Signage / Awning Permit Application

**Ann Machado - RE: Fwd: 194 Warren Ave. - Permit #2014-02530**

Sign - not drawn
 to scale

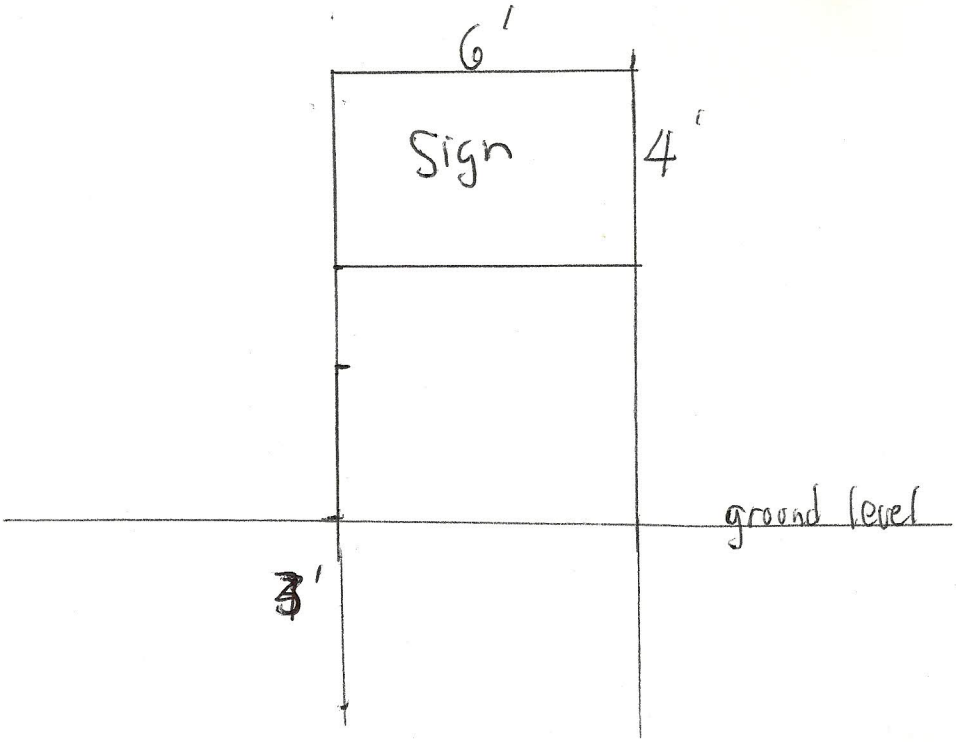
I need to know how tall the sign is from grade to the top of the sign. before I can sign off for zoning.

Hi Ann. 9'
